Planning Case officer
Richard A Gilbert
Kirklees Council
By email

I wish to query with you the latest changes to the plans for planning application 2021/91914 at 28 Northorpe Lane, Mirfield. In my previous correspondence of 16 June 2022 (Ref 1, see attachment and also at https://www.kirklees.gov.uk/beta/planning-applications/search-for-planning-applications/downloadaddocument.aspx?application_number=2021%2f91914&file_reference=938089&size=505814

Drawing **Proposed Site Layout**

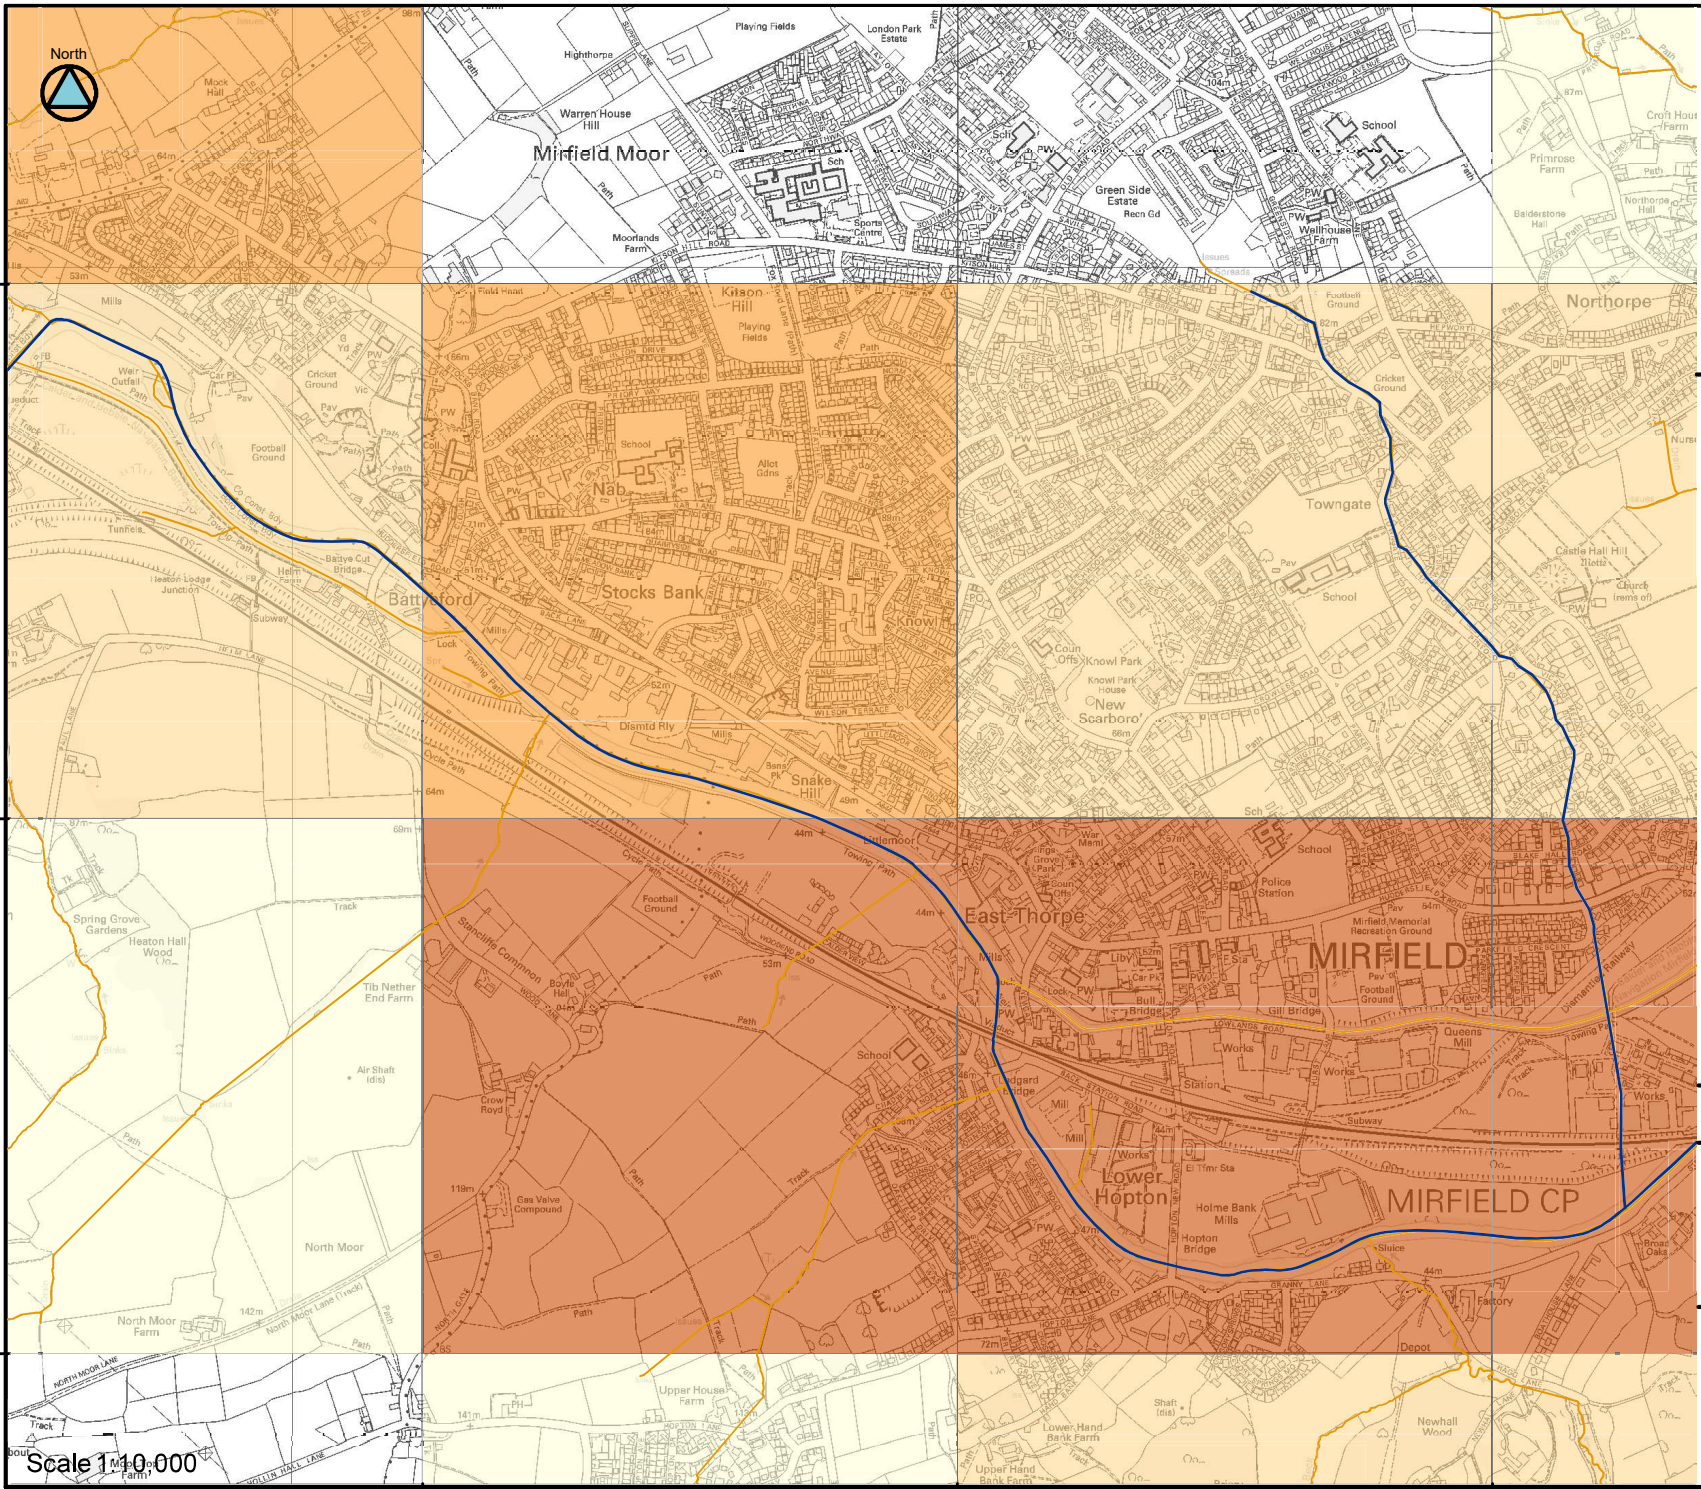
), I explained my observation that the current plans *at the time* did not show a minimum distance stipulated by Kirklees Planning Officers of 21 meters being present between the habitable windows of Plot 11 of the application and the existing property at 3 Northorpe Court.

The application has since been revised on 12 July 2022 but no correction on the plans increasing the separation between the two buildings has taken place. Please could you tell me if:

1. The applicant has been made aware of this present failure to meet the Planning Officers' previous stipulation?
2. How this application can possibly be approved in its current state considering the above situation?

3. Why has the same '21 metre between habitable windows' ruling not been applied to Plot 11 and 3 Northorpe Court ?
4. Furthermore, on the matter of safe road radii and unsighted bends, please could you explain why there is a dangerous bend still present on the current plans adjacent to plot 28 ? I described the danger and non-compliance with Kirklees' Council's own advice to the applicant, in my letter of 16 June 2022?
